TfNSW Reference: SYD17/01416/09

Department's Reference: SSD 8800

**RESPONSE TO SUBMISSIONS FOR PARRAMATTA LEAGUES CLUB HOTEL  
1 EELS PLACE, PARRAMATTA**

# TfNSW Operational Traffic Modelling Team Review and Comments

4.4 Access and Circulation Match Day

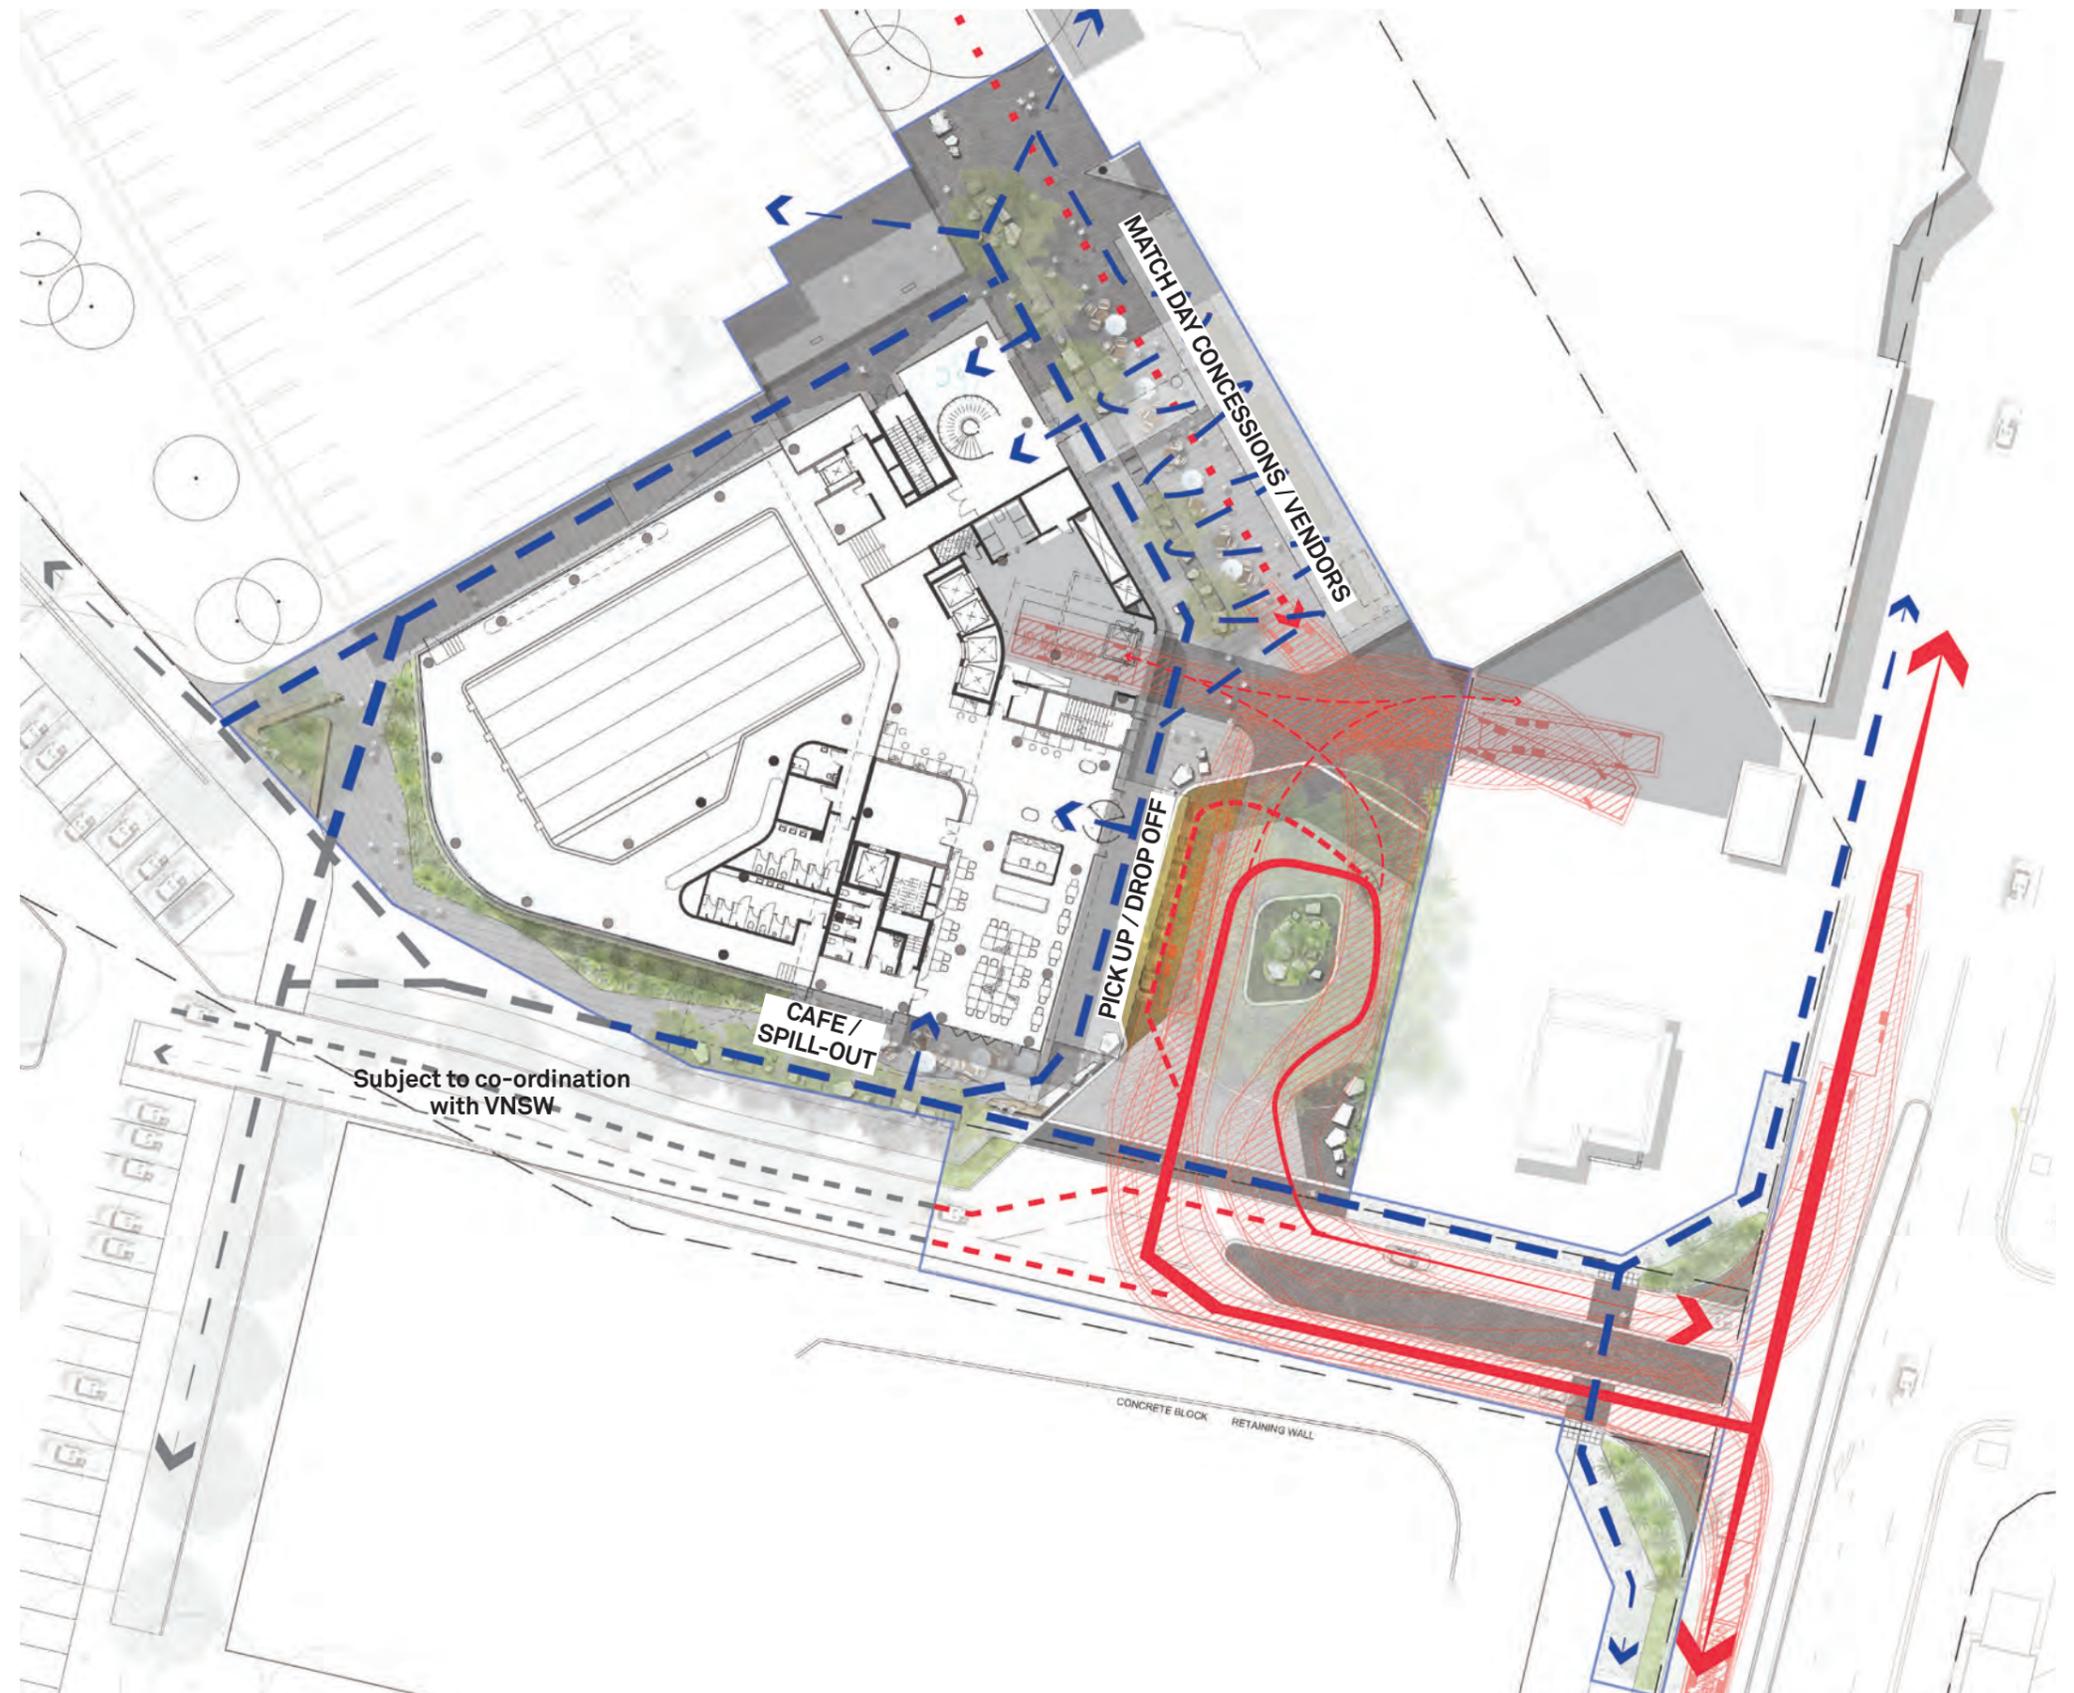
1. It is noted that holding lines have now been proposed on both approaches of the one lane two-way arrangement on Eels Walk. TfNSW raises concern regarding the proximity of the painted zebra crossing on Eels Walk that causes potential vehicular conflict with pedestrians as this is a conflict and decision-making point for motorists.

TfNSW recommends the positioning of the painted zebra crossing is to be reconsidered.
